Martin Nugent
01254 828060
D3/12/0735

Drafted 30 November 2012

**Planning Applications, Ribble Valley District
3/12/0735 Jackson's Barn, Bolton by Bowland Road, Sawley**

| Drawing no 6007                                               |

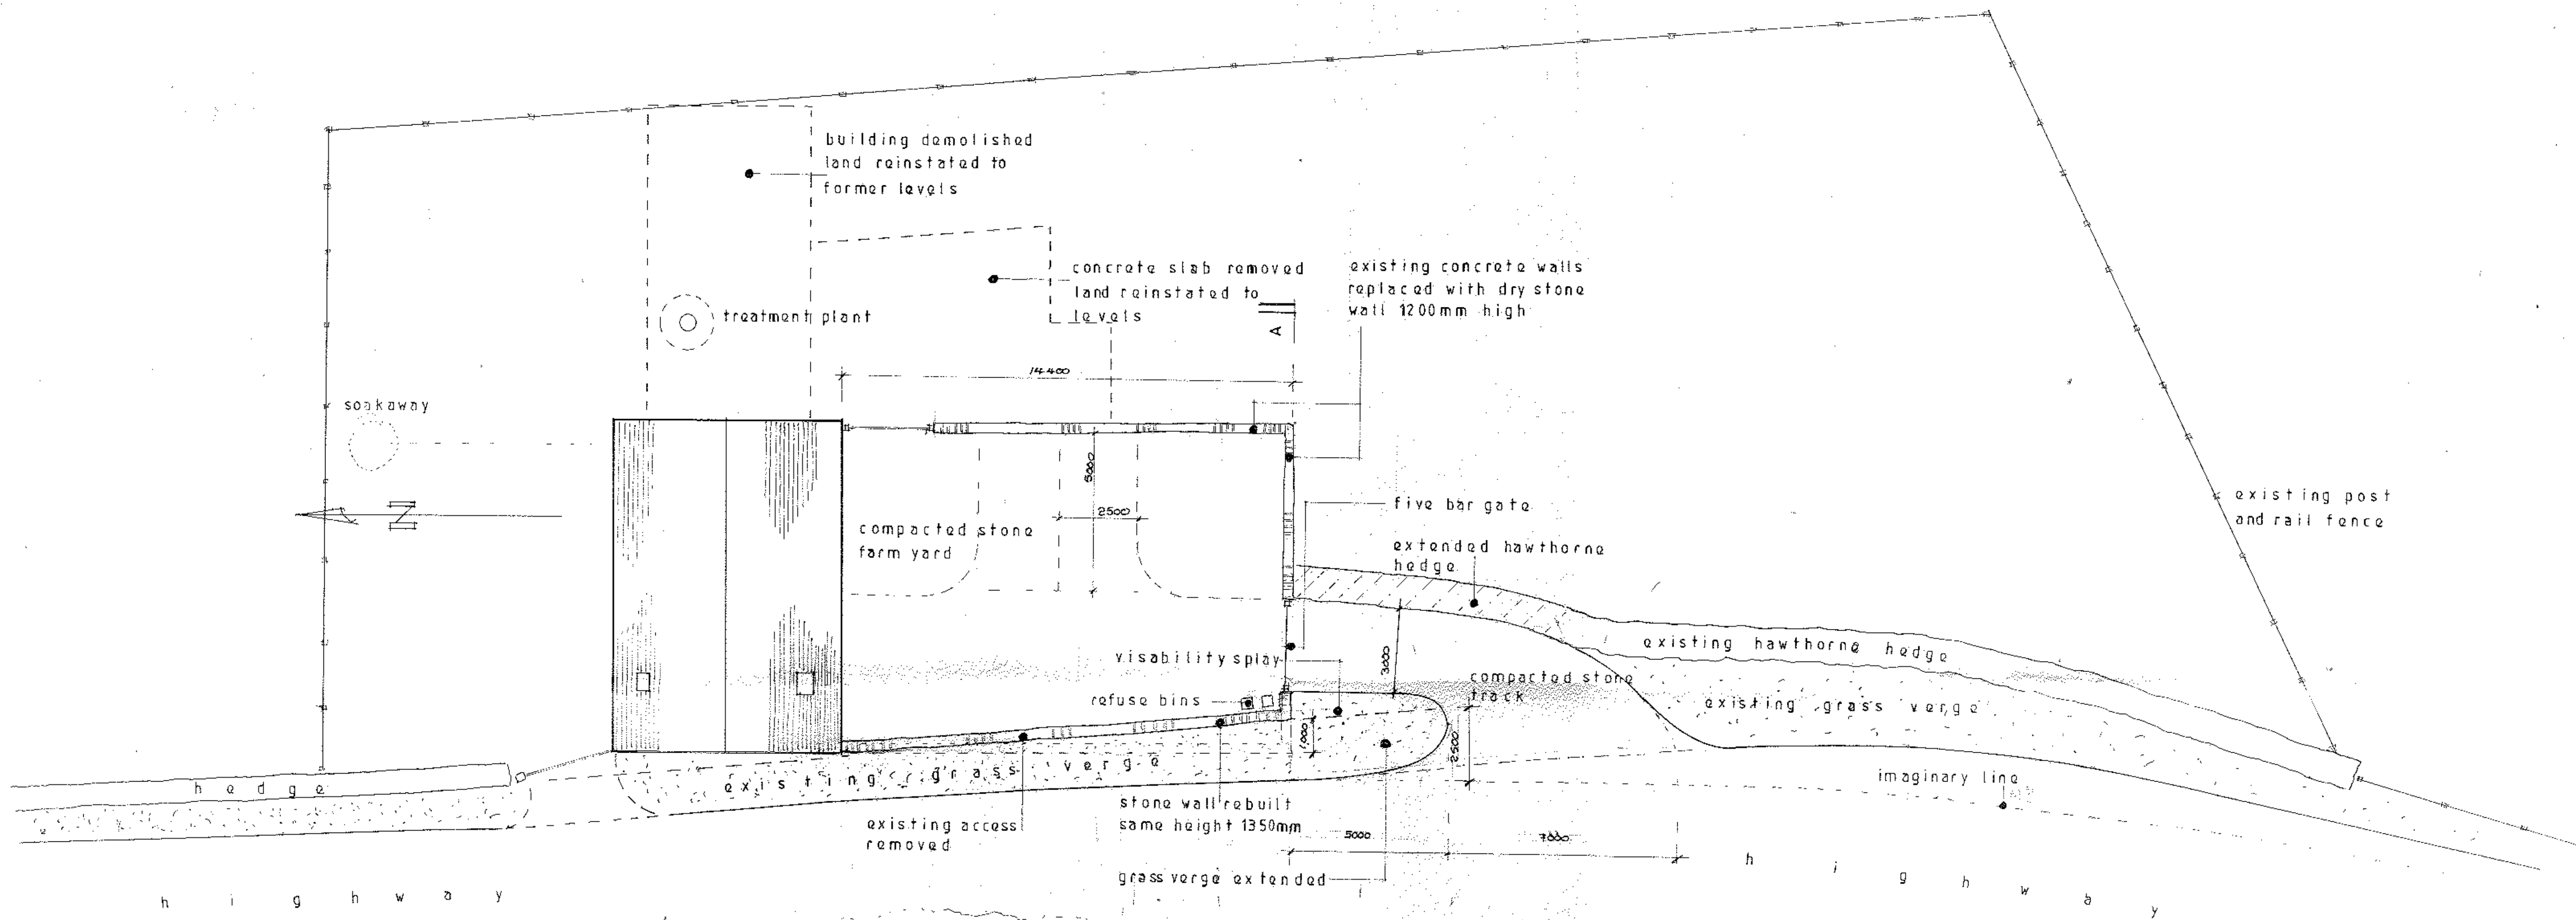
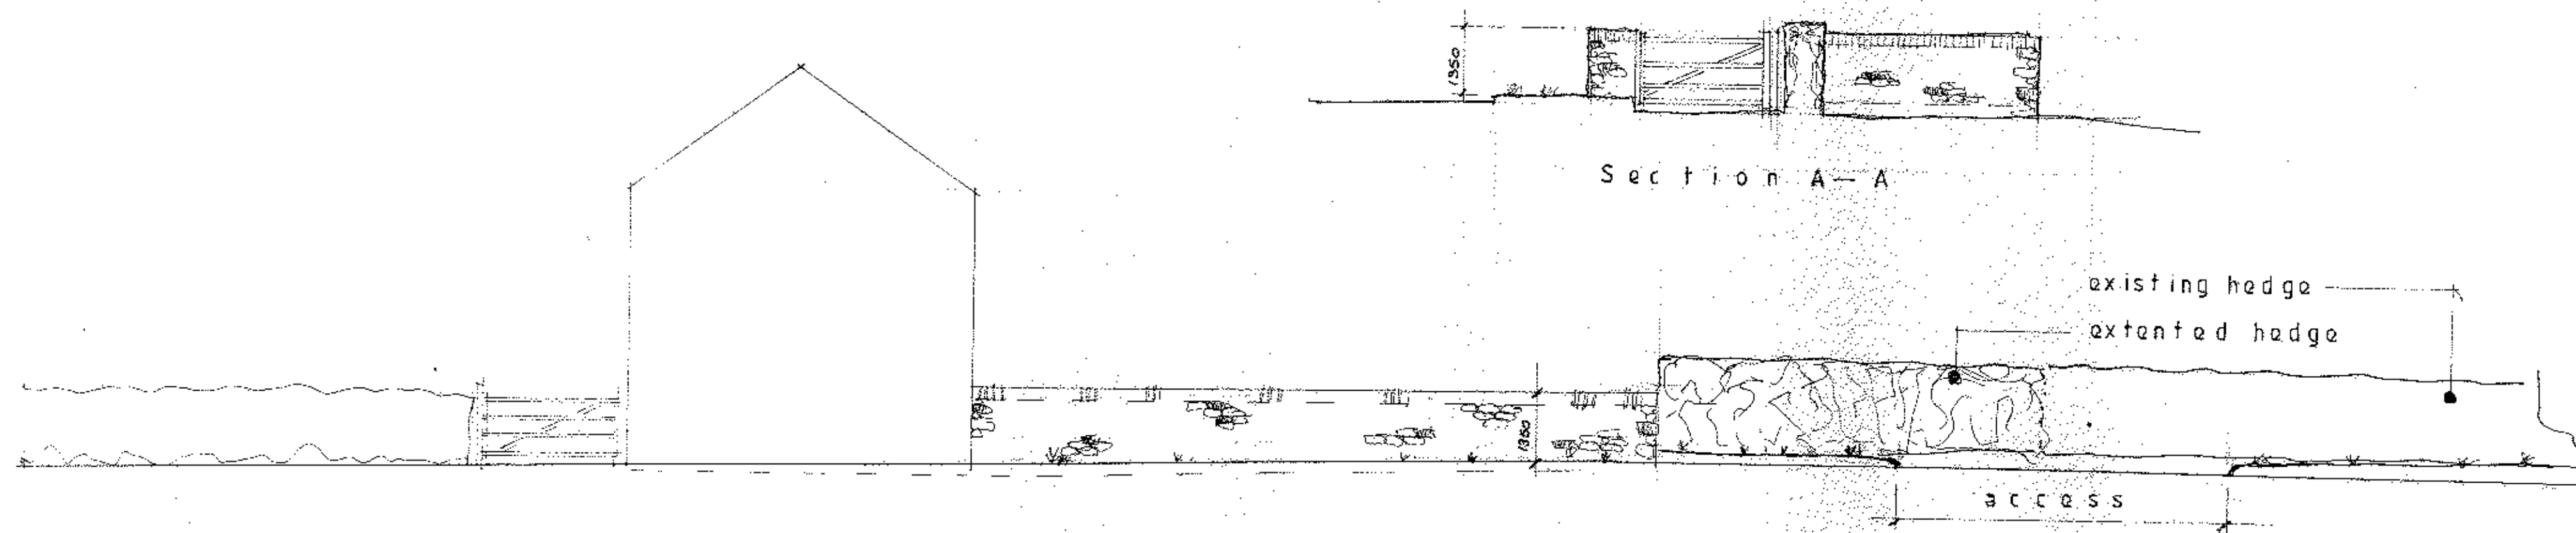
The alterations being made to the projection of the boundary wall to the north of the access will allow a suitable sightline to be achieved, in excess of 125m measured from 2.4m back from the edge of carriageway. A similar sightline can be readily achieved to the south.

The existing verge must be maintained and there must be no new planting or construction within the sightline splays on land under the control of the applicant to a height above 0.9metres. This is to ensure that visibility splays can be retained and safe access to and from the site can be maintained.

Subject to the applicant completing the development as per the submitted site plan drawing, Reference 6007, I have no objections to the development.
